Subject: Mow Cottage FP/80/21/DOC

Engineers Comments Regarding Surface Water Drainage

| Drawing Number                                                                                                                           | 2106/SK3 |             | Revision<br>- |

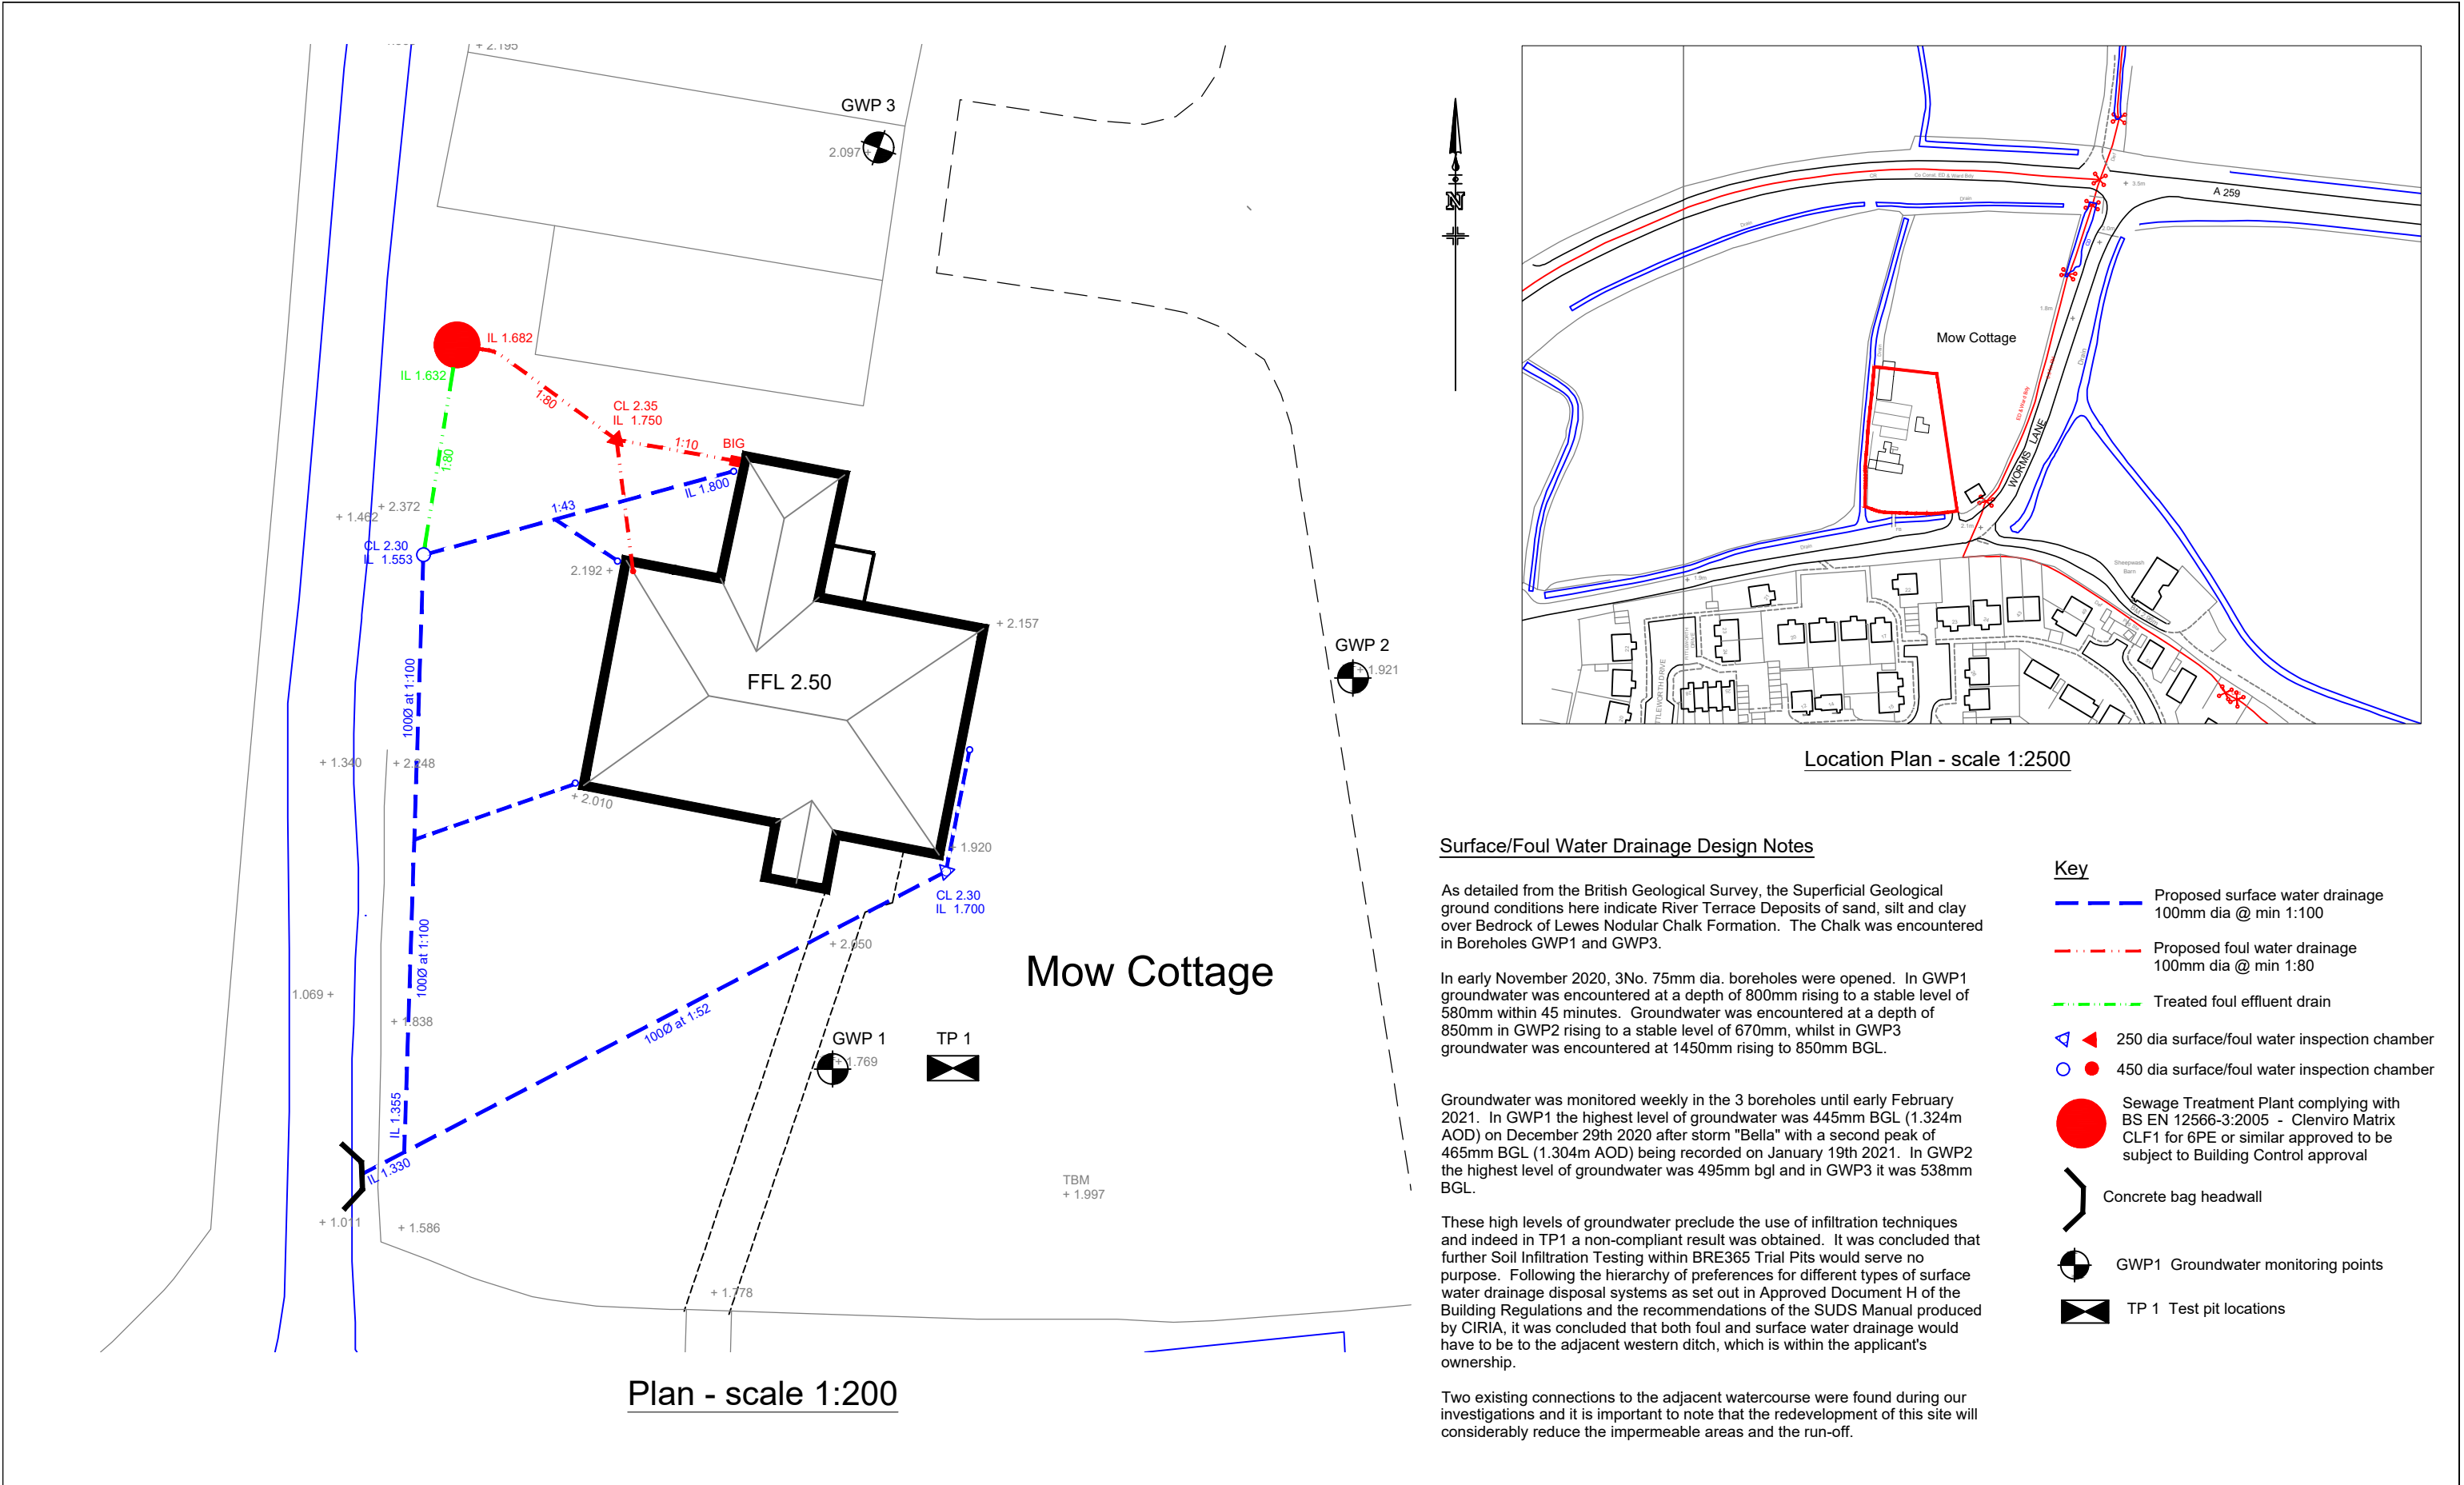
At present there is no effort made to restrict or slow the discharge rate of surface water to the ditch. It is difficult to discern an appropriate discharge rate due to the history of the site. Technically it is fair to consider the site a brownfield site as a house was formerly located there (before the fire in 2006) and it is assumed that there is existing hard standing on site as the design notes state that "redevelopment of this site will considerably reduce the impermeable areas and run off". However, we have no evidence to substantiate this claim, no historic floor plans, no photos, no previous impermeable area plan and no proposed impermeable area plan. If we consider the site as brownfield then policy indicates that we should expect 50% betterment on the existing discharge rates.

In order to better understand the existing system I would expect the pre-development runoff rate calculations to be provided, even if these are to show that the new design will require no restriction of flow due to the reduction in impermeable area.

In addition, even if no storage is required to attenuate flows before a restricted discharge (i.e. tanks or ponds/basins prior to an orifice or Hydrobrake) then we would still like to see effort made to slow the rate of discharge in other ways. It is suggested that the use of water butts with diverter kits could achieve this to an extent. It is unclear whether a driveway is being introduced for the development, but if so, diverting surface water through lined permeable paving would have the dual benefit of slowing flows and providing water treatment.

1. A sumped manhole provided upstream of the headwall where the pipes connect.
2. If inspection chambers aren't provided on all pipe connections then please include a construction detail drawing for these junctions.
3. A note regarding pipe materials and cover types on inspection chambers/manholes on layout.
4. Please include hard bed, soft bed and top of bank levels on the headwall construction detail drawings.
